From: Gregg, Robert <Robert.Gregg@lancashire.gov.uk>
Sent: 20 May 2020 16:58
To: Rebecca Bowers <Rebecca.Bowers@ribblevalley.gov.uk>
Subject: Amended parking plan 17 Hillcrest Road, Langho 3/2020/0089

telephone 07470 282883
drawing number D 1101/20/03
scale 1-100

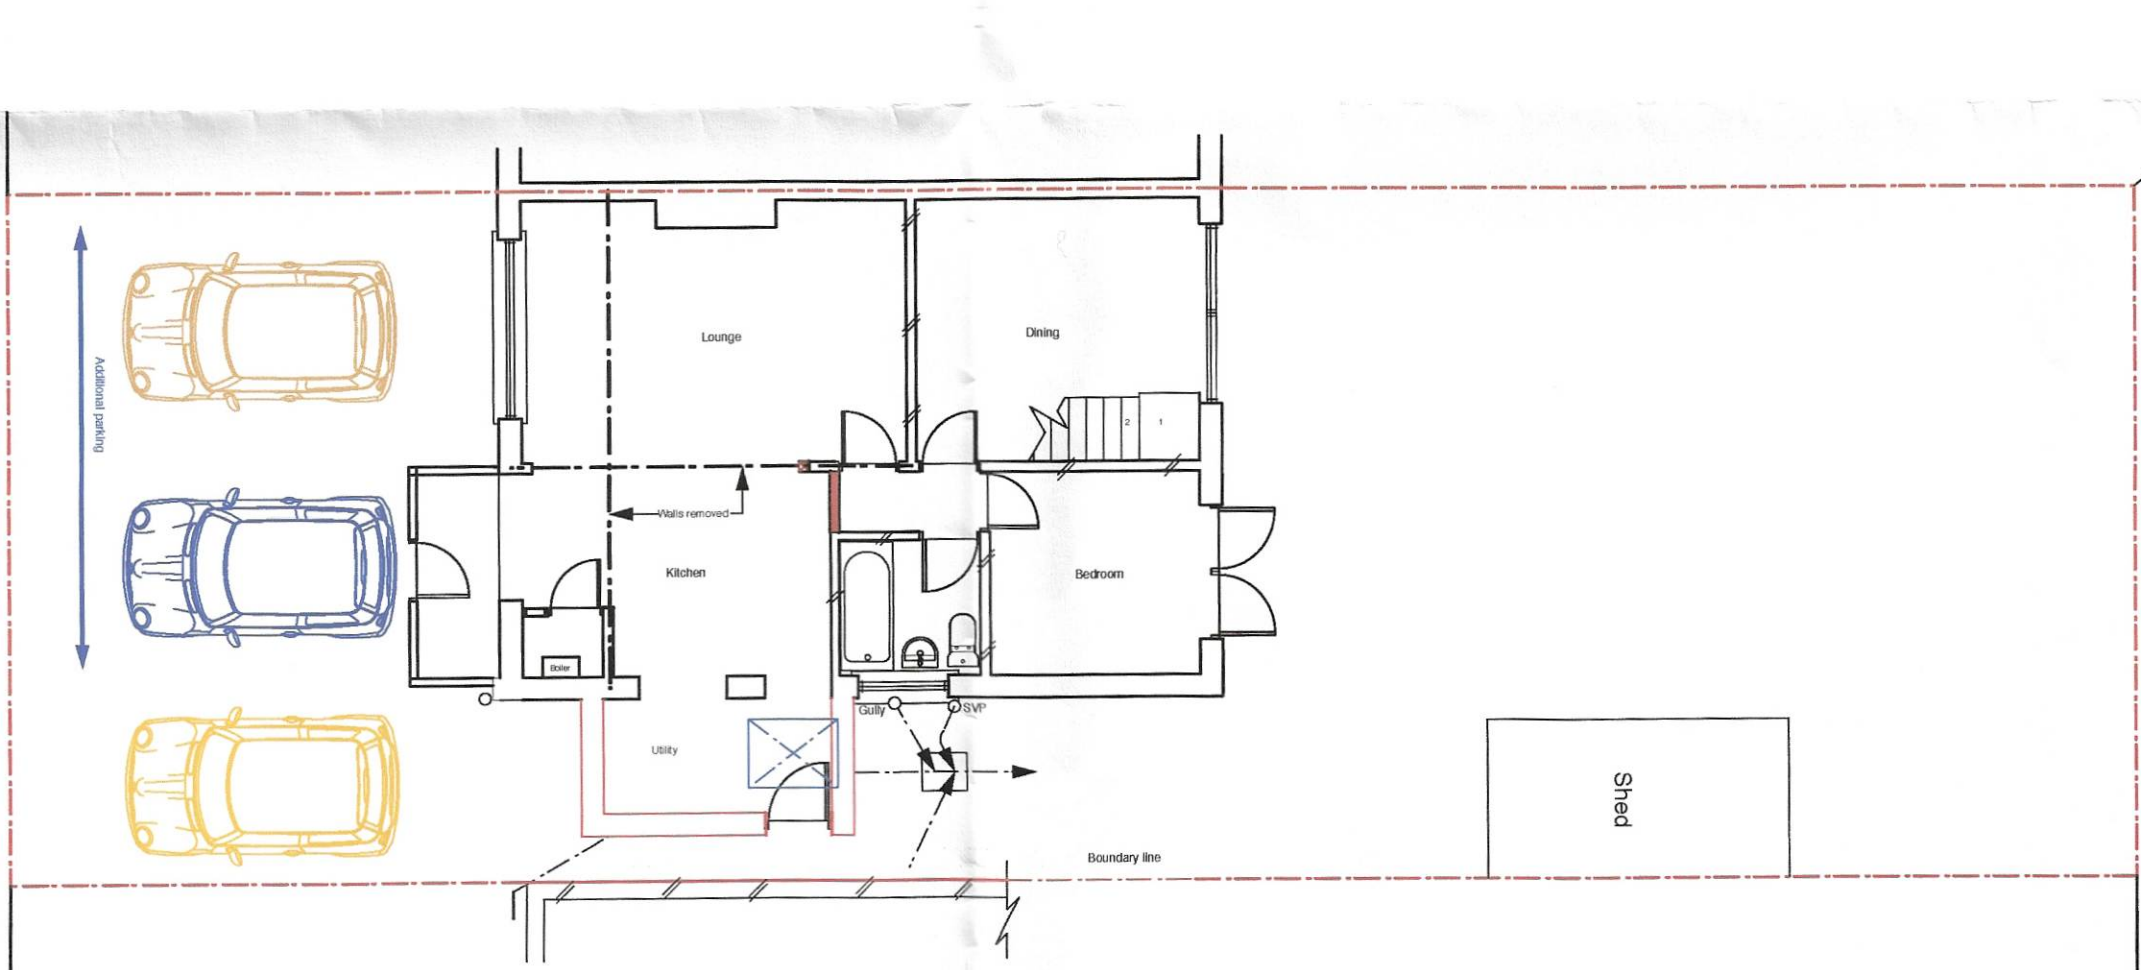
Having been in receipt of an amended plan for the above proposal, I can now confirm that I am satisfied the proposal, in accordance with revised drawing D 1101/20/03 would not raise any highway concerns and as such I would raise no objection to the proposal on highway grounds.
